2094 - Frasers Broadway
Drawing List Scheme Design (Development Application)
Block 1 - PPR Submission - Drawing List Amendment Descriptions

Rev 00 PPR Submission_Draft
Rev 01 PPR Submission

A-SK-1358

Title
BLOCK 1+4N
BASEMENT 01

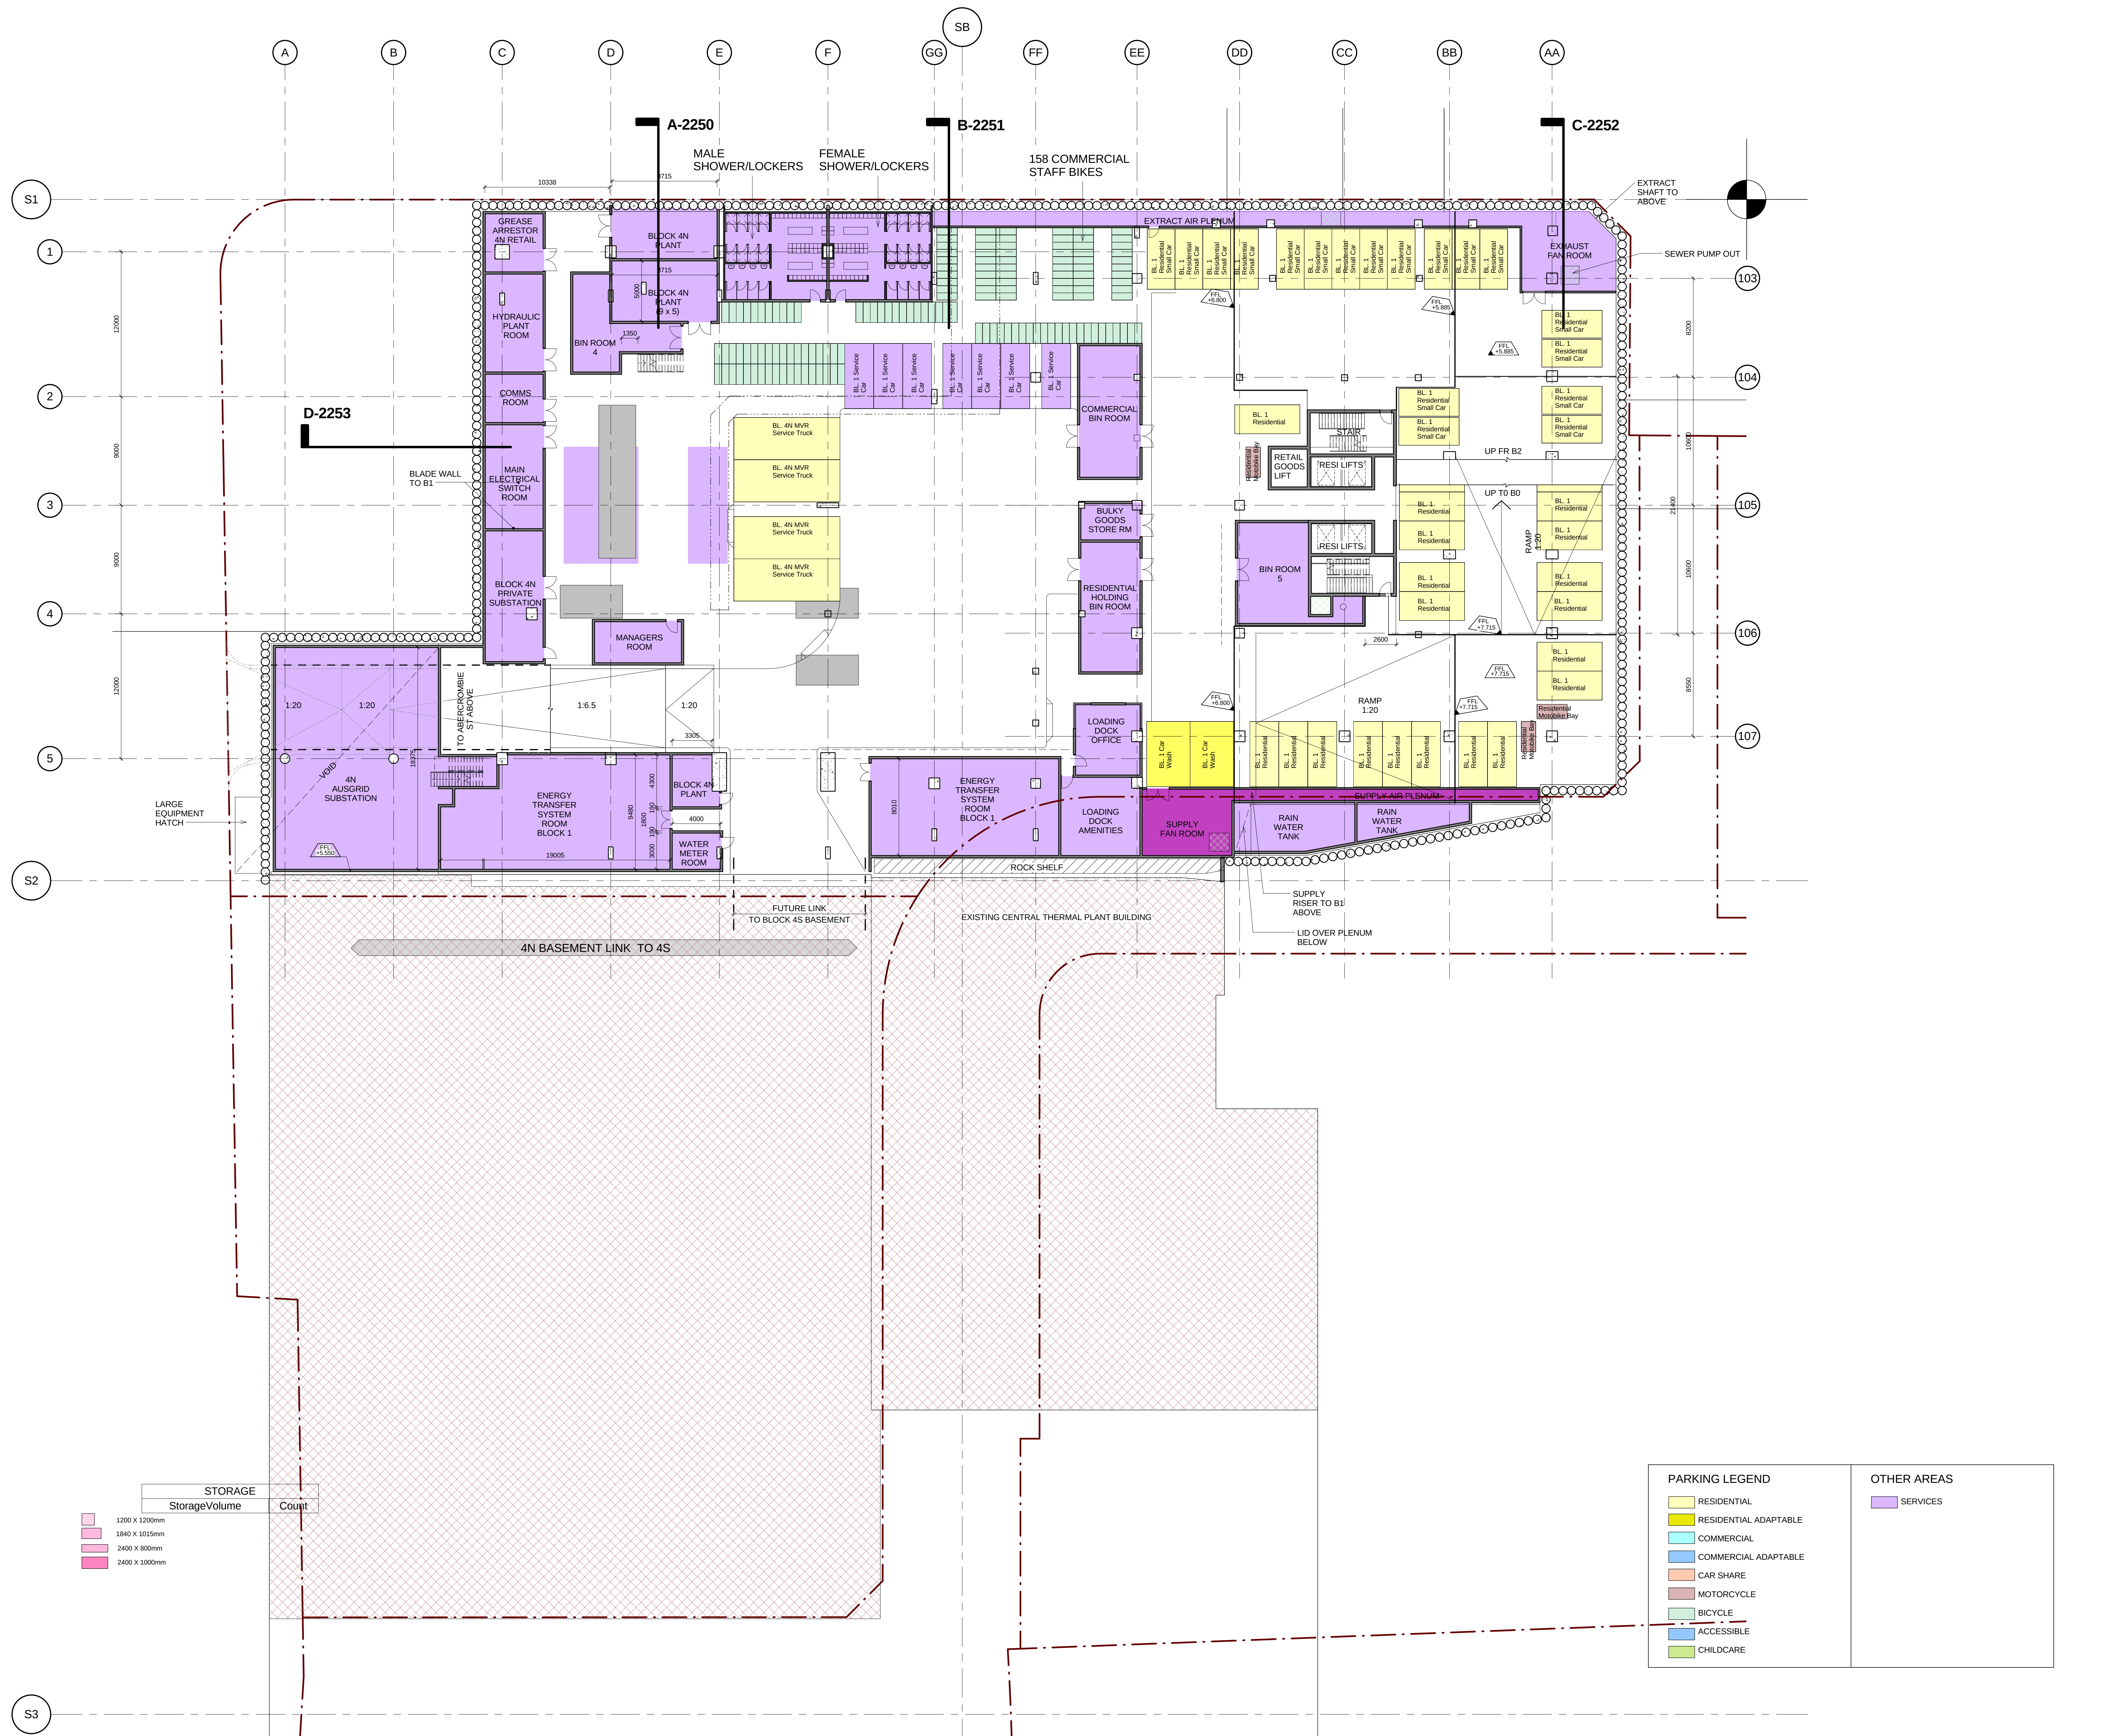
PA A1 1500	Landscaping	1:500	A0	OO		no change.
PA A1 1600	Public Domain Plan	1:200	A0	OO		no change.
PA A1 1605	Staging Plan	1:250	A0	OO		no change.
General Arrangement Plans						
1750 - 1899						
PA A1 1755	B1 Basement 04 Plan	1:200	A1	01	revised	incorporating revised parking layouts and storage provision. The latter as requested by DPE/Council
PA A1 1756	B1 Basement 03 Plan	1:200	A1	01	revised	incorporating revised parking layouts and storage provision. The latter as requested by DPE/Council
PA A1 1757	B1 Basement 02 Plan	1:200	A1	01	revised	incorporating revised parking layouts and storage provision. The latter as requested by DPE/Council
PA A1 1758	B1 Basement 01 Plan	1:200	A1	01	revised	incorporating revised parking layouts and storage provision. The latter as requested by DPE/Council
PA A1 1759	B1 Basement 00 Plan	1:200	A1	01	revised	incorporating revised parking layouts and storage provision. The latter as requested by DPE/Council
